# CITY OF ALBUQUERQUE

RE: **Lot 1 Block 2 SAD 228  
8024 Canoncito Dr. NW  
Volcano Cliffs Subdivision  
Grading and Drainage Plan  
Engineers Stamp Date 11/6/19 (D10D003C1)**

GRADING AND DRAINAGE - SITE PLAN

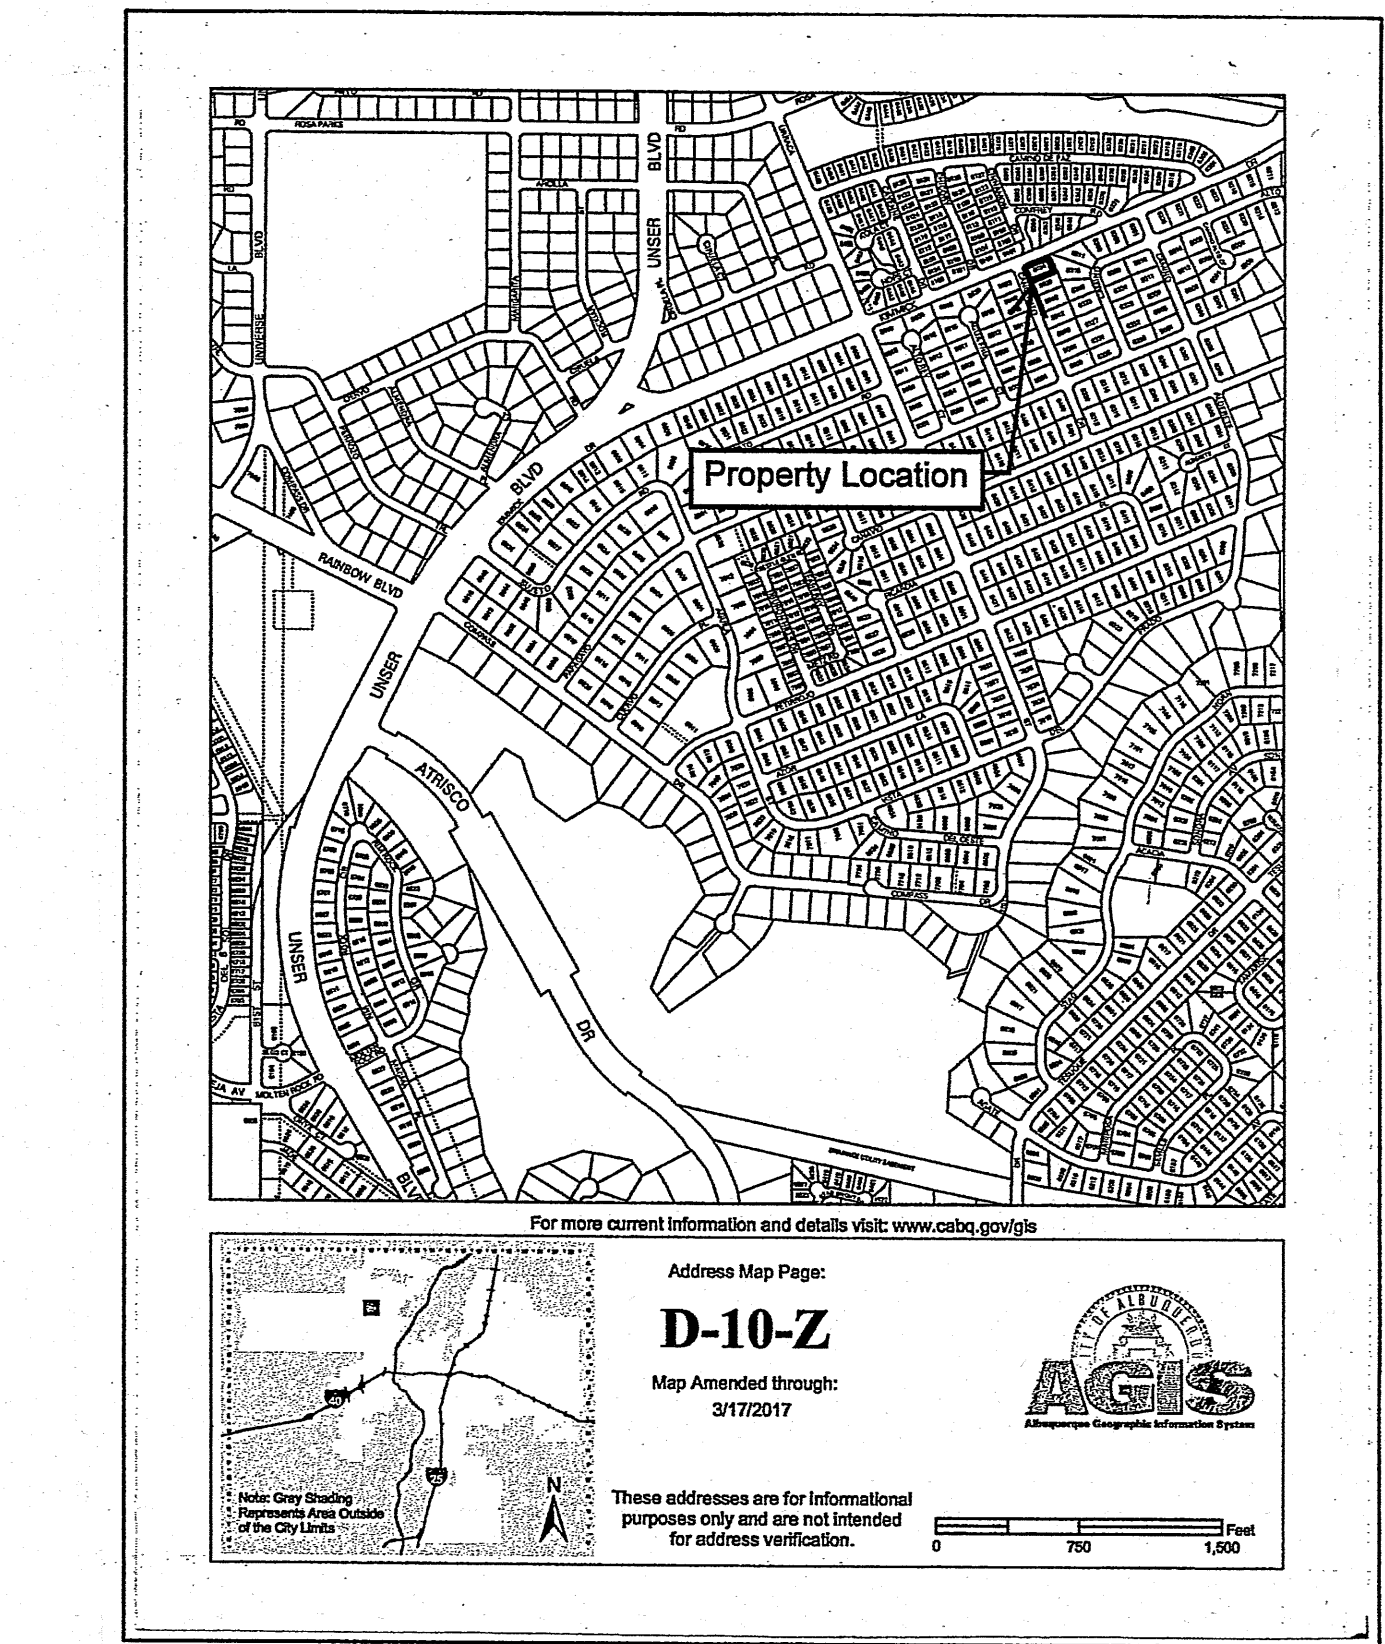
- Remove the openings in the rear yard. Provide openings in new garden wall so that flows can exit onto Kimmick Drive at the N.W. corner.
- No fees will be charged for the resubmittal.
